Appeal Decision

Appeal Ref: APP/R5510/W/16/3148219

27A & 27B, Daleham Drive, Hillingdon, Middlesex UB8 3HW

- The appeal is made under section 78 of the Town and Country Planning Act 1990 against a failure to give notice within the prescribed period of a decision on an application for planning permission.
 - The appeal is made by Mr Seamus Murphy against the Council of the London Borough of Hillingdon.
 - The application Ref 67783/APP/2015/4003 is dated 23 October 2015.
 - The development proposed is 2 semi-detached dwellinghouses.
-

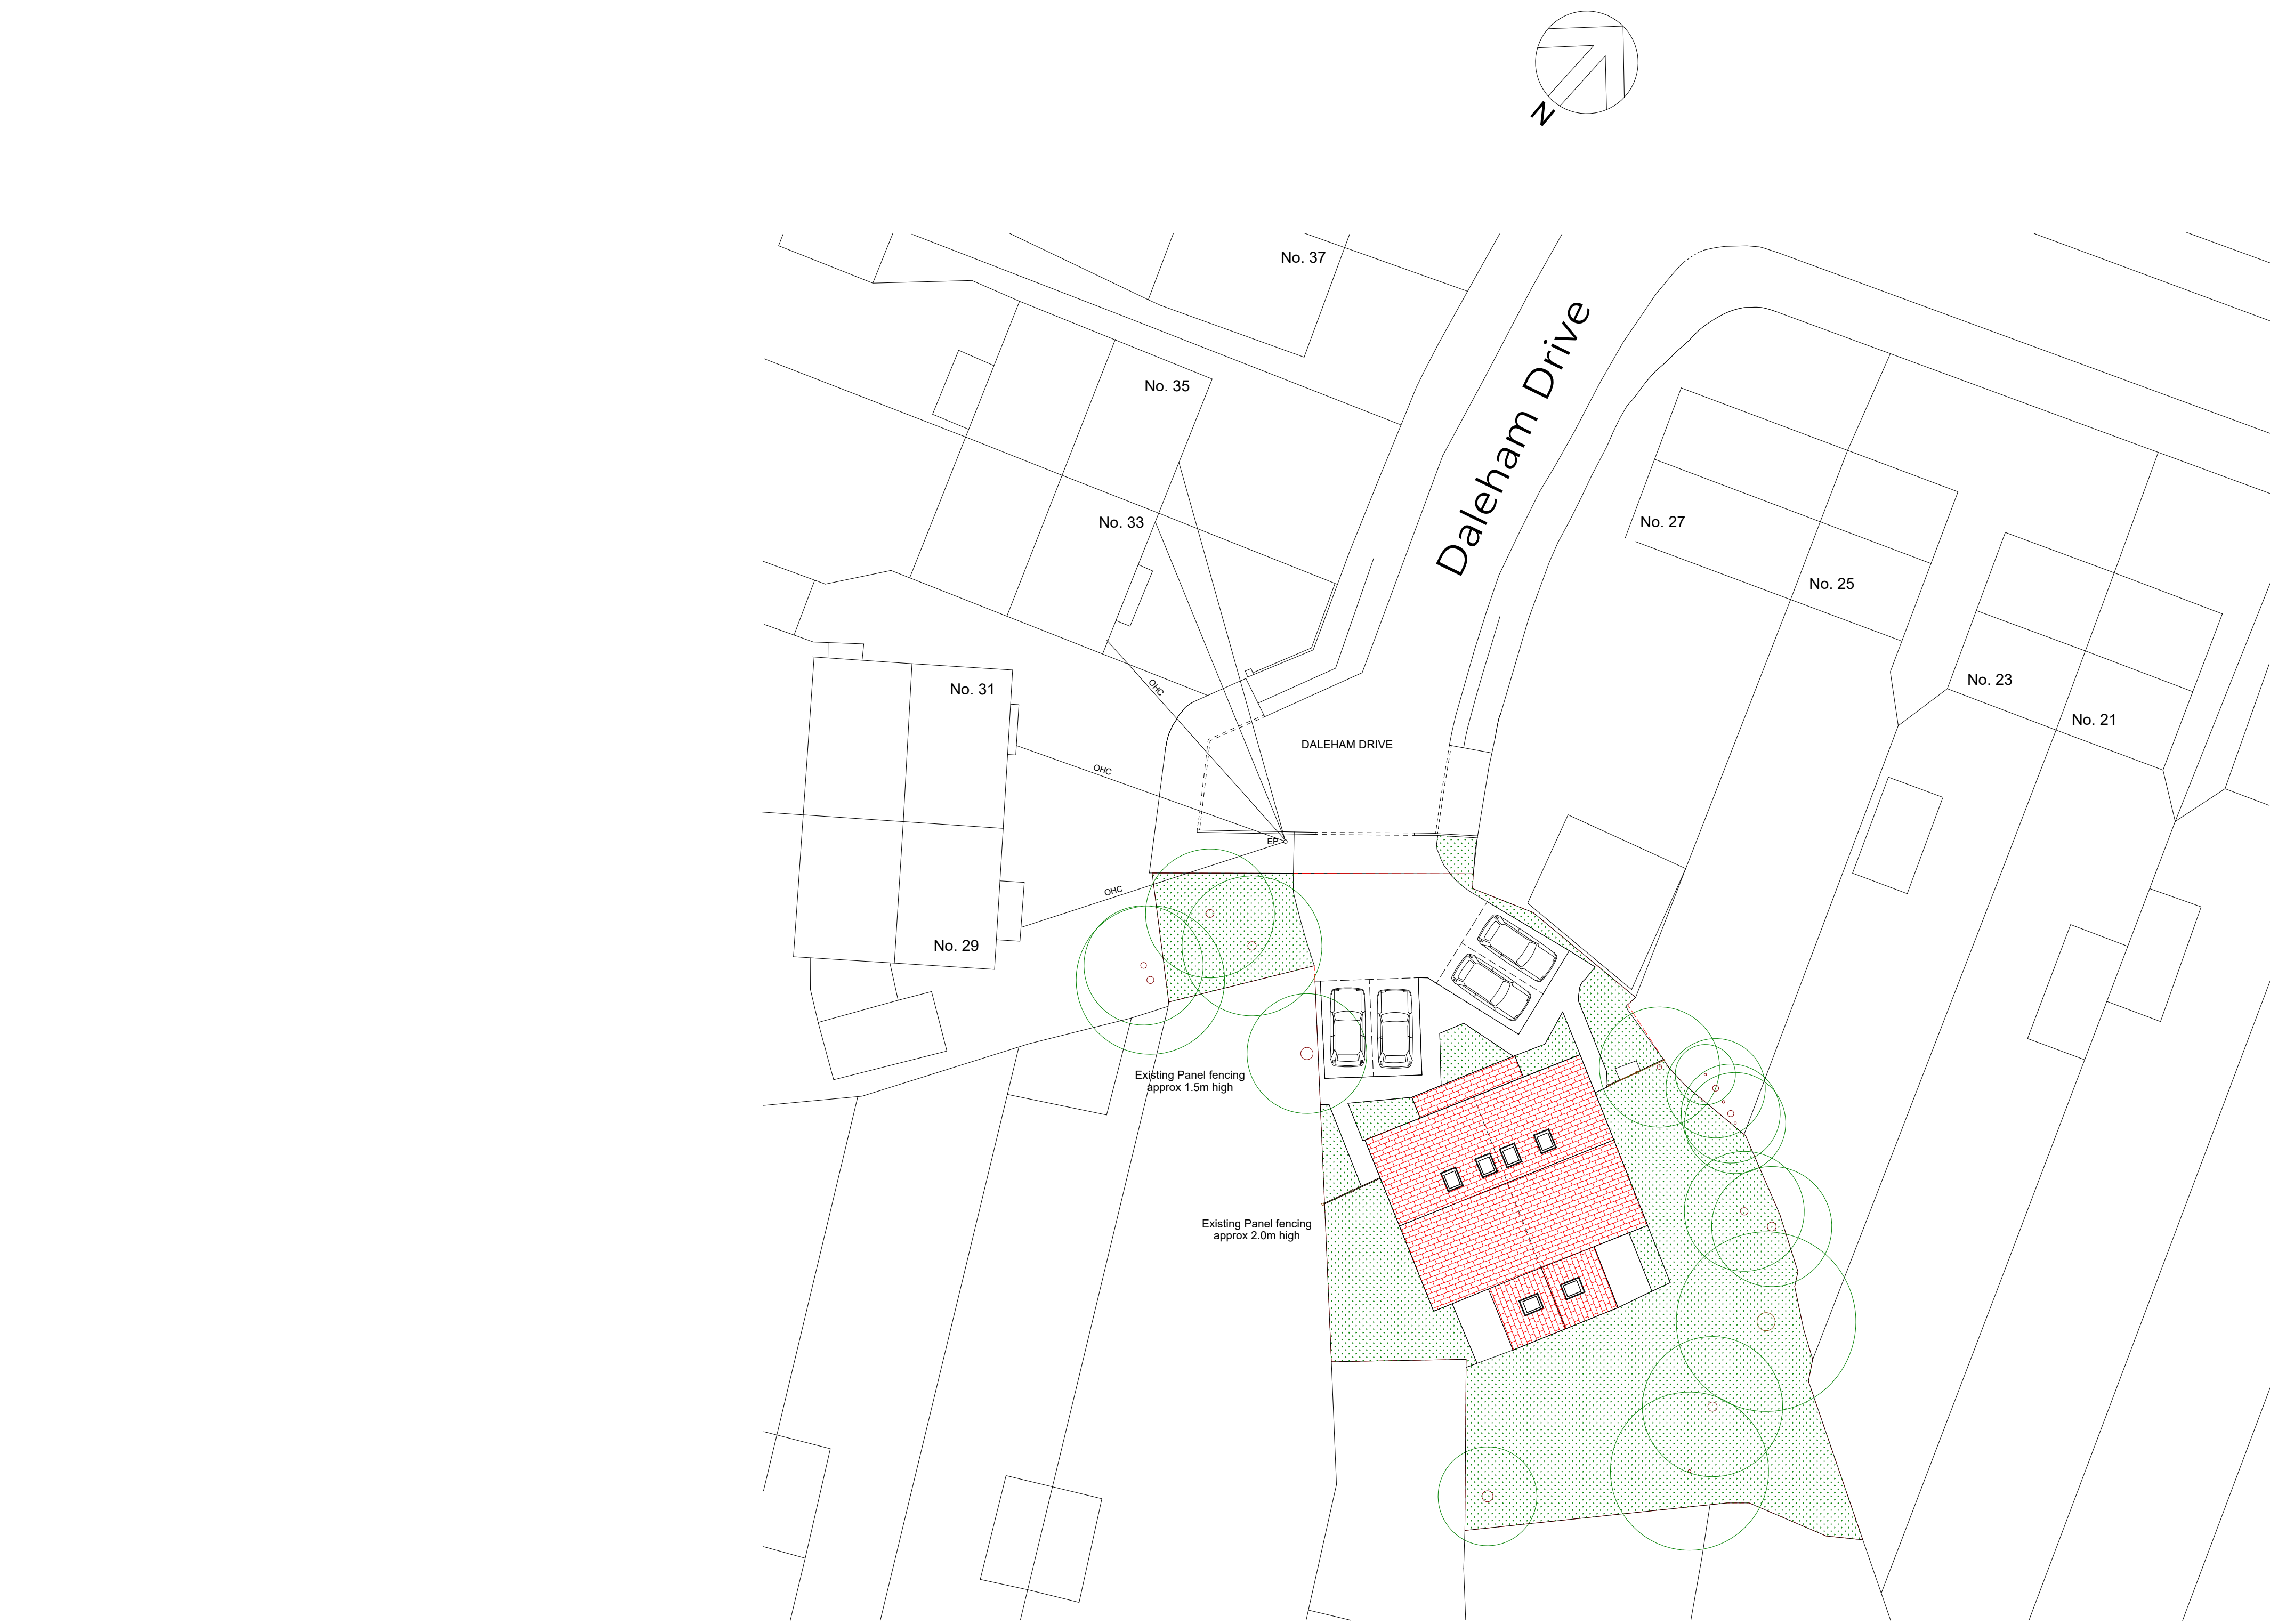
9. The relationship of the dwellings to those surrounding allows some variety to occur, including in the choice of materials, without resulting in material harm and they are sufficiently set apart from the nearby frontage housing along Daleham Drive not to appear in stark contrast. Whilst the wide area of hard surfaced parking space to the front of the houses does appear out of character the proposal includes a plan for additional landscaping. Re-configuring the parking spaces to introduce some landscaping would soften the currently harsh appearance of this front area.

11. The Council has provided no evidence over the effect of the development on surface water run-off rates. However, the requirement for the forecourt to be re-landscaped offers the opportunity for the drainage of this area to be considered further through the detailed measures that are required to be implemented.

- i) Within 3 months of the date of this decision a scheme for hard and soft landscaping in accordance with plan reference CL/15/213/PSP/REVA shall have been submitted for the written approval of the local planning authority and the scheme shall include a timetable for its implementation.
